**RE: NEW EDUCATION BUILDING AT WENONA SCHOOL (SSD 6952)**

Thank you for your letter dated 29<sup>th</sup> July 2015, relating to the Proposal State Significant Development at Wenona School. This letter sets the matters in regard to this development identified by Council. Council does not object to the proposed new facility at Wenona School; however there are a number of issues set out below:

Greg Sherlock  
Planning and Development Advisor.

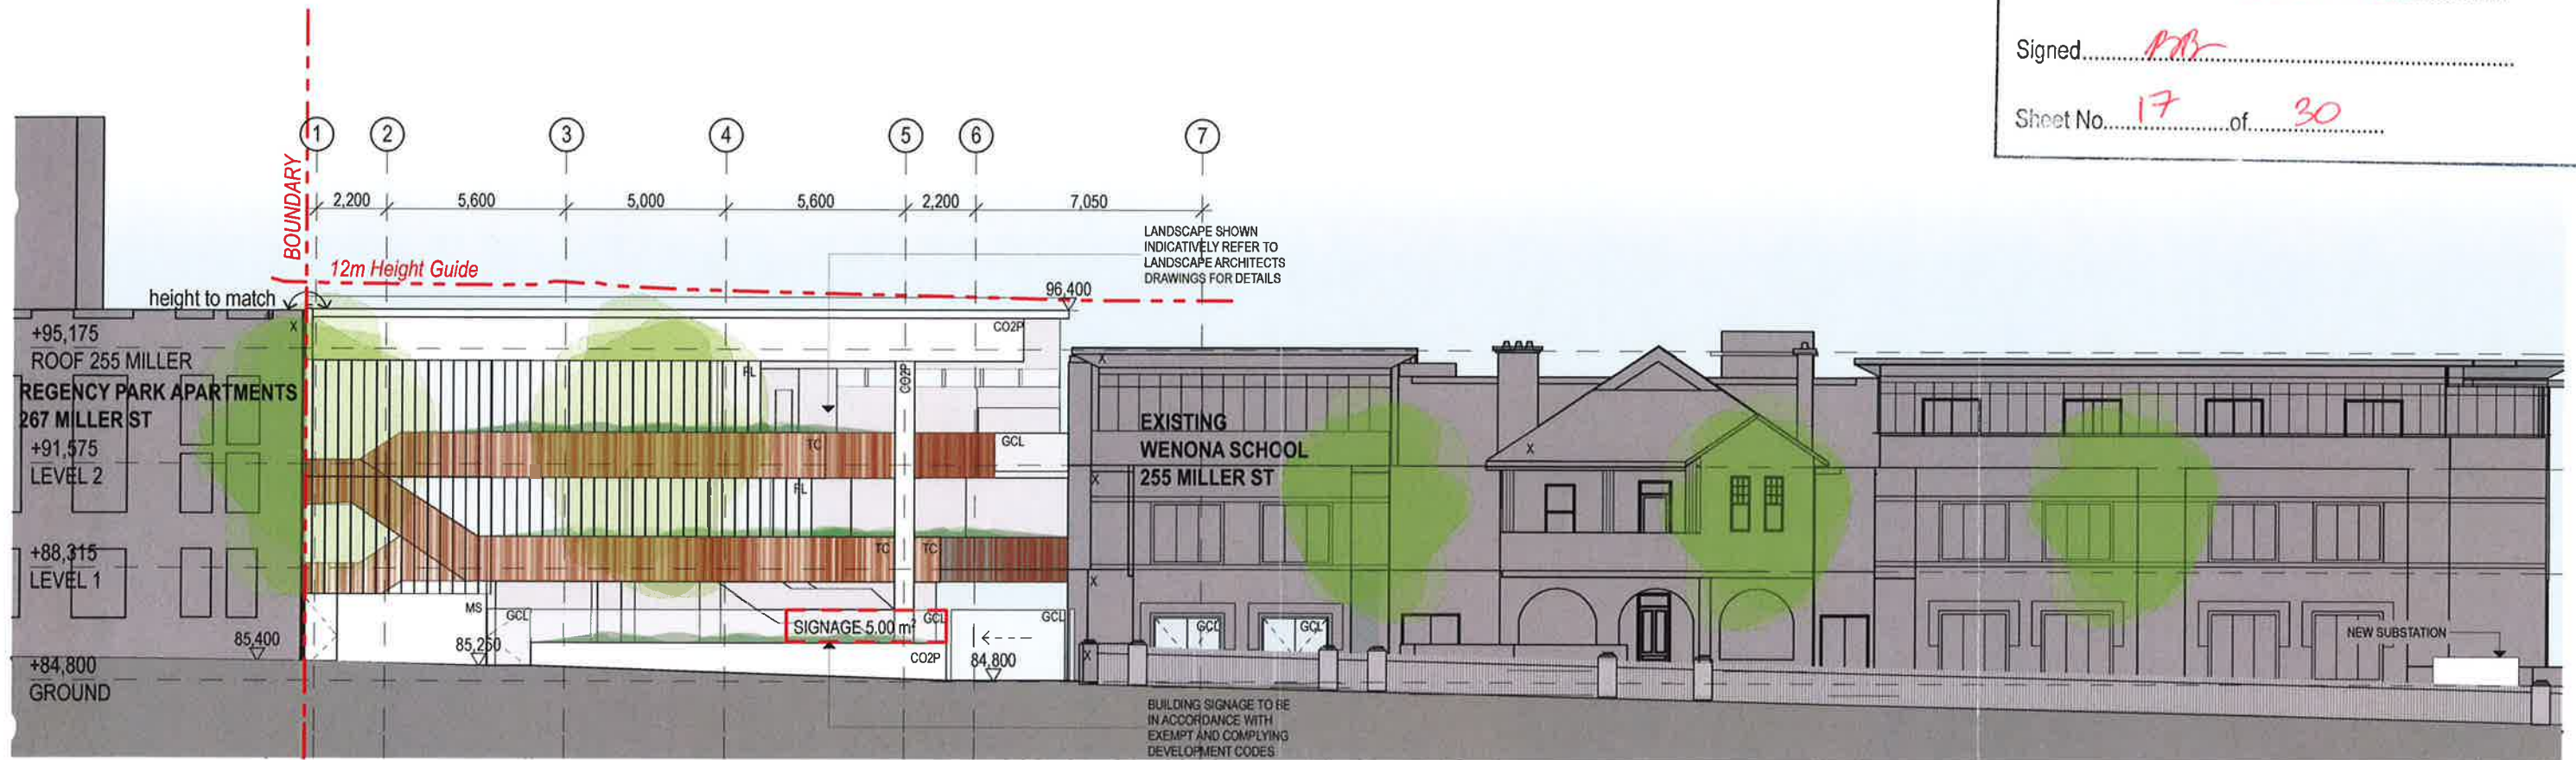
- Height of the proposed development breaches LEP height control, and in normal circumstances a planning proposal be made to amend the control however, the proposed parapet height to Miller Street matches neighboring structures and the major offending structure is a lift overrun, therefore it is appropriate that the assessment be based on merit of the proposal.

- The proposed access to/from Miller Street of the new development is supported, however clause 4.4A (1) (a) seeks to promote continuous active street frontages at a street level, the street frontage activation shown in the proposal could be improved to fall within the aims of the LEP.
